Engineers Comments Regarding Surface Water Drainage

Application Reference:	A/153/25/DOC	Reviewer Reference:	ADC/EXT3/RW
Planning Officer:	Jessica Riches	Date of Review:	08/12/2025
Site Name:	Land North of Water Lane Angmering BN16 4EJ		
Application Description:	Approval of details reserved by condition imposed under A/88/24/S73 relation to condition 5-drainage arrangements for bund along Northern boundary with A27.		
Assessment Number:	2 of 2

NORTHERN NOISE BUND
CATCHMENT AREA

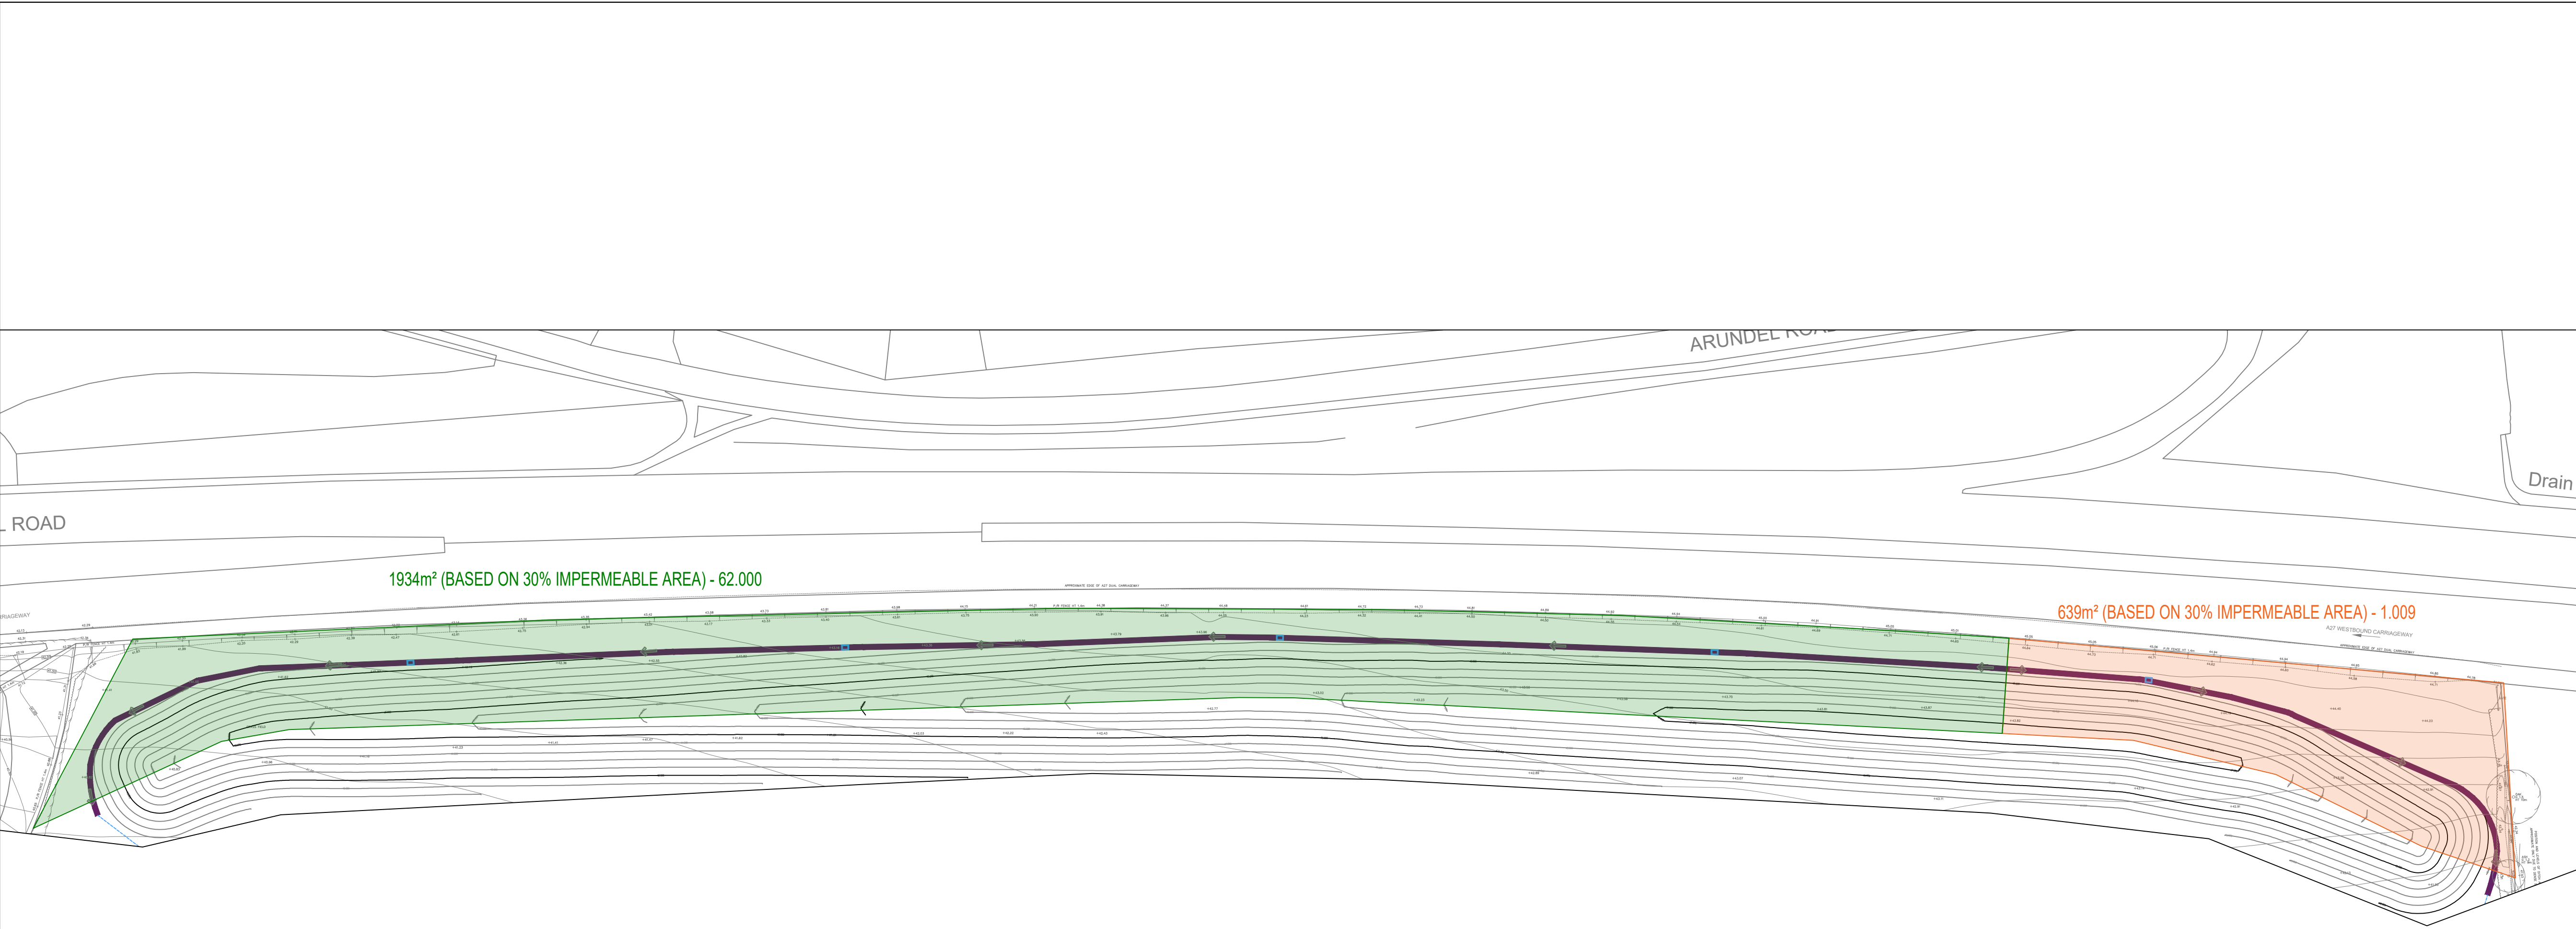
1. Please see the attached comment tracker for detailed comments relating to the submission.
2. **The calculation pack submitted does not match the catchment plans submitted. We are unable to verify the additional areas areas have been included in the overall design.**

ADC Drainage Comments	Designer Response	ADC Drainage Comments		
Date:	05/02/2025		08/12/2025		
Condition Number: 5 – Drainage Bund					
Comment Number					
1.	Please provide detailed construction details of the filter drain		Typical Construction details provided.		
2.	Please provide calculations confirming the capacity of the filter drain and also the capacity of the swale where the filter drain is discharging to. Additional flows from the development should be taken into account.		Calculations do not include addition of filter drain. Impermeable areas plan does not match calculation pack for noted outfall locations. PN 62.000 on calculation pack has impermeable area 0.033 Ha. Drawing shows impermeable area 0.193 Ha. PN 1.009 noted as swale on drawings,

noted as 450mm pipe in calculation pack. PN1.009 noted as having 0.063 Ha. area on drawing and 0.055 Ha. On application pack. Please provide updated calculation pack with supporting catchment plan to ensure the areas are properly considered.		
3.	Please confirm how the surface water from the swale is discharging. If infiltration has been chosen as a method of discharge, please provide soakaway testing as per BRE365.		Swale to discharge to wider drainage network. This option is acceptable given site constraints and conditions.		
4.	Please provide groundwater monitor results taken during the winter months September-March.		Groundwater monitoring not required given design. Floatation calculations not required.
